Office of
Environment
& Heritage

Your reference: 08_0129 MOD 1
Our reference: DOC11/21692, File No. LIC07/2522-03
Contact: Hamish Rutherford, (02) 4908 6824

31 May 2011

ORICA KOORAGANG ISLAND UPRATE MODIFICATION REQUEST (08_0129 MOD 1)

Figure 4 | Layout of proposed scrubber (existing prill tower in grey)

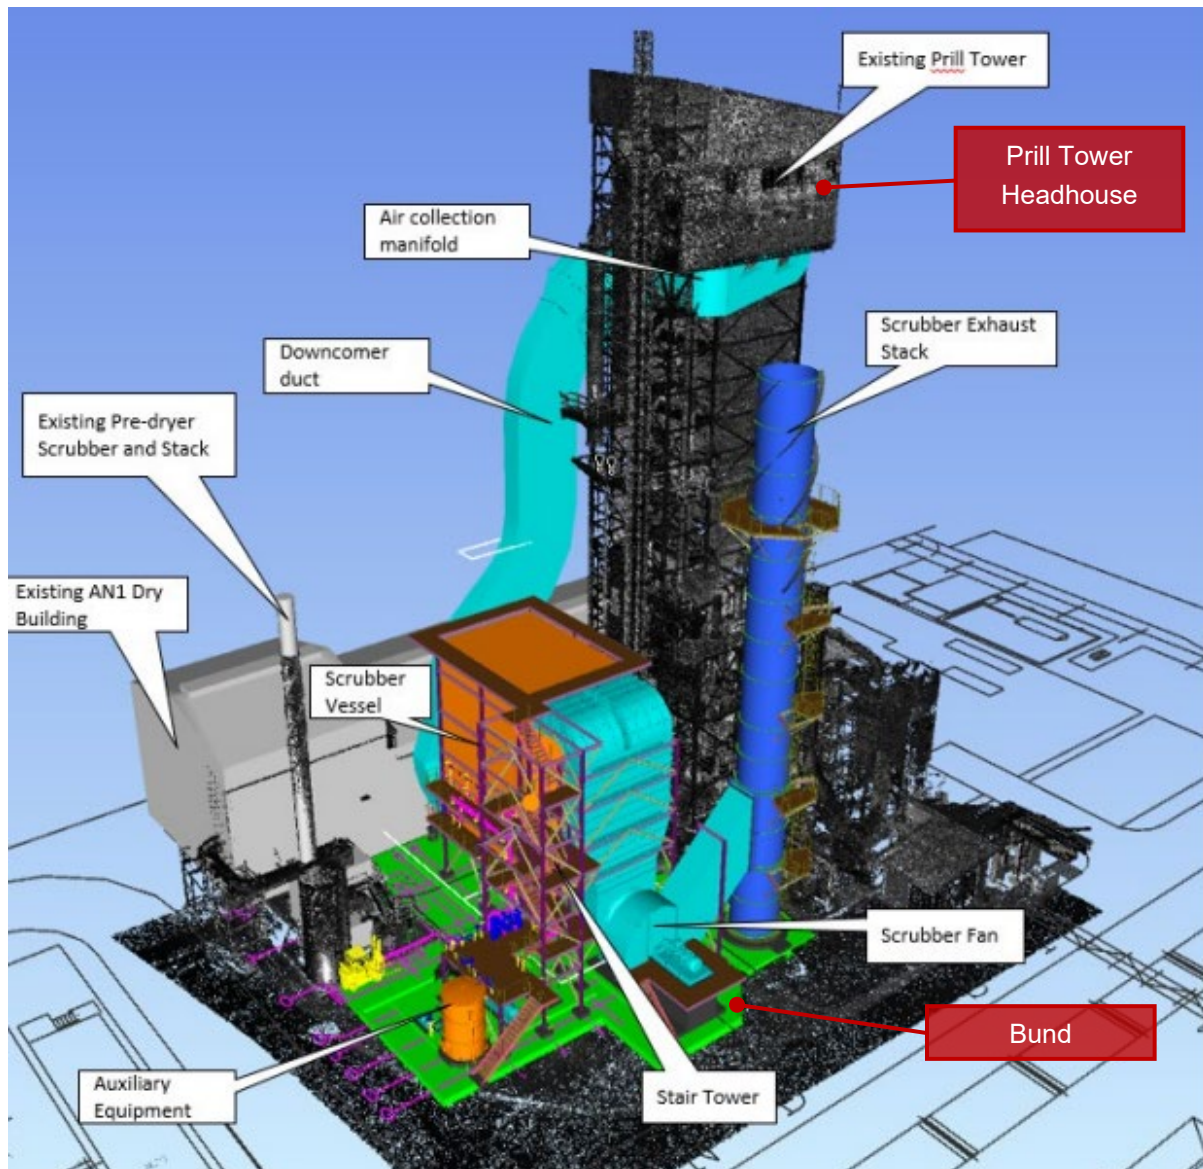
OEH is aware from the original and Environmental Assessment and recent discussions with the proponent that they are investigating options for reducing emissions from the Ammonium Nitrate Plant No.1 (ANP1) Prill Tower, which represents the largest particulate point source at the premises. A reduction in emissions from the Prill Tower is may result in the reduction in fine particulate emissions to levels below the assessment criteria.

In addressing this issue OEH recommends that, should you intend on granting approval of the proposed modification to the project approval, a condition be included within the project approval that requires the proponent the investigate and implement options to reduce fine particulate emissions from the ANP1 Prill Tower within 2 years. Should you decide to grant approval OEH advises you to consult NSW Health for advice on potential impacts from fine particles at the predicted levels on Receptor 3.
